Application for Removal or Variation of a Condition following Grant of Planning Permission or
Listed Building Consent

Erection of two storey extension to rear, two dormer windows to front and new porch.

S.22/2358/HHOLD

Project Hillcrest		
Project Address Hillcrest, Oakridge Lynch, Gloucestershire, GL6 7NR		
Job No.	062	
Drawing Title	Proposed Roof Plan	
Drawn by	Checked by	Date
RRA	PR	January '24
Scale	1:50@A1	
Drawing No.	Revision	
P(2)03	A	
Drawing Status	PLANNING

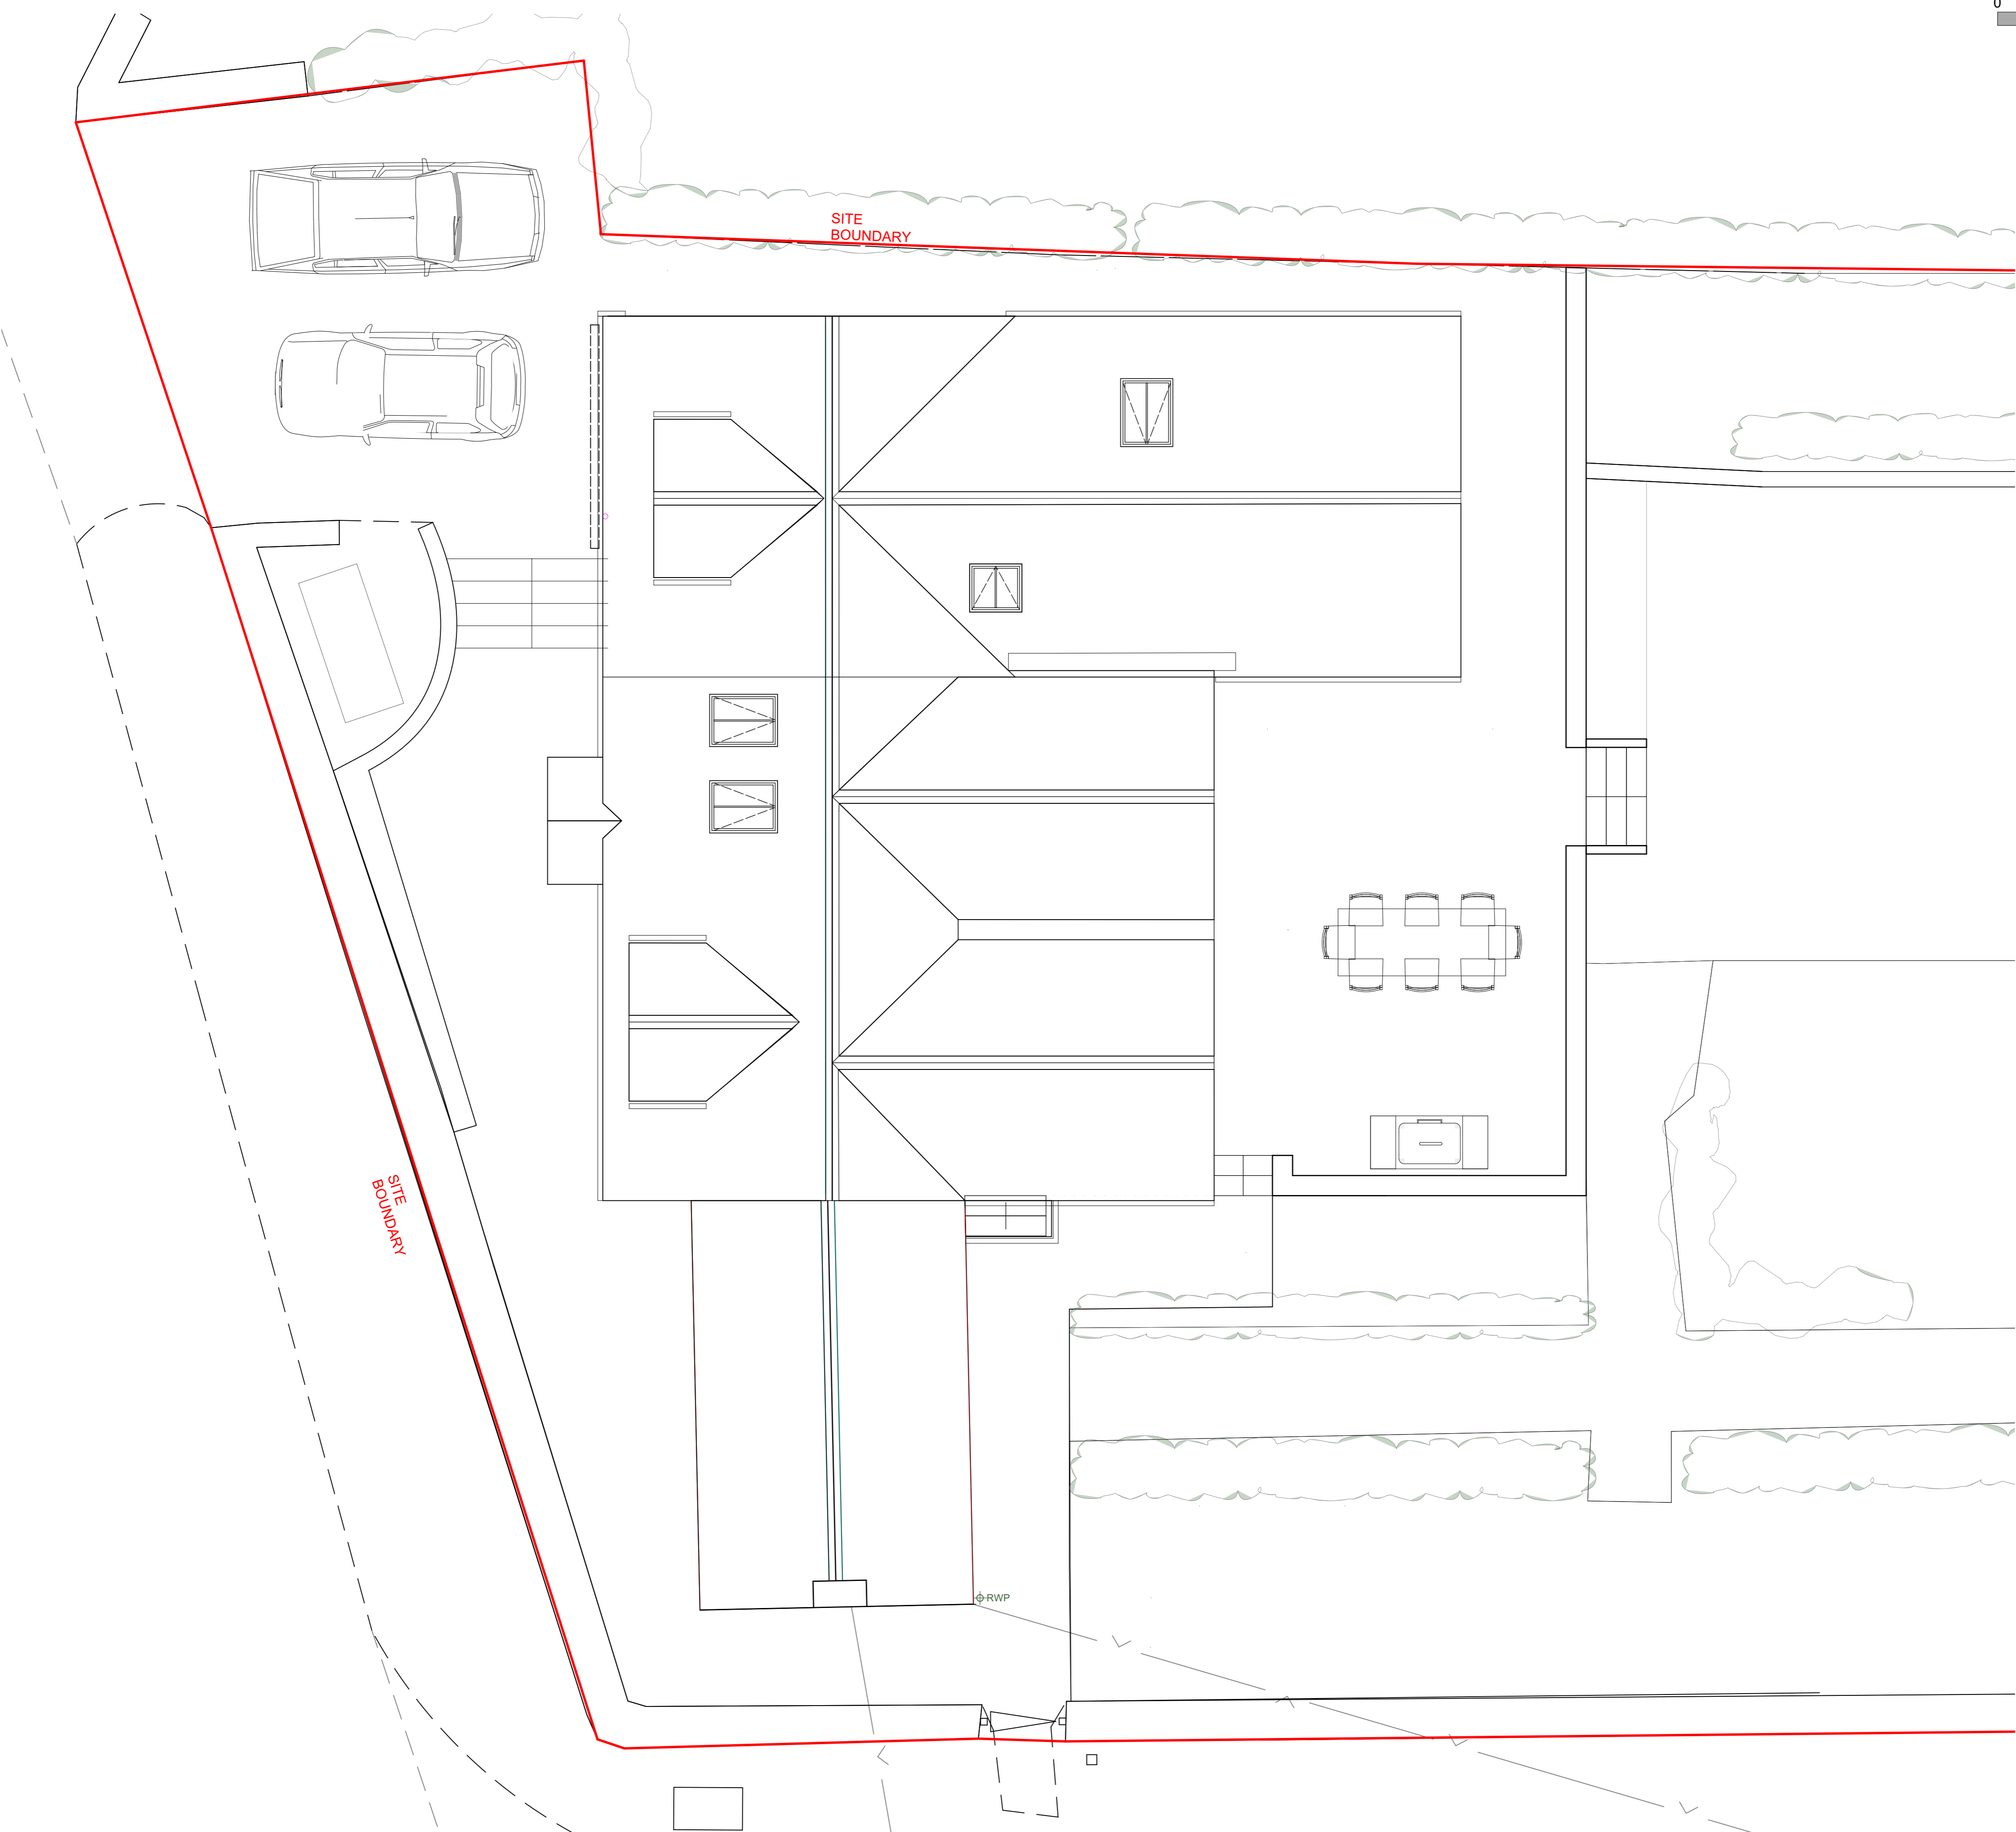
- 1) Addition of render to the north west and north east elevations.
- 2) 1no. new window to the Study to replace the 2no. existing windows on the north west elevation.
- 3) Amended canopy to the main entrance on the north elevation.
- 4) Number of proposed rooflights reduced.
- 5) Slightly larger rooflight to the north east elevation.

Omit drawings 4264 P(2)01 - Proposed GF Plan, 4264 P(2)03 - Proposed Roof Plan and 4264 P(2)04 - Proposed Elevations.
Add drawings 062-P(2)01 Rev.A - Proposed GF Plan, 062-P(2)03 Rev.A - Proposed Roof Plan and 062-P(2)04 Rev.A - Proposed Elevations.
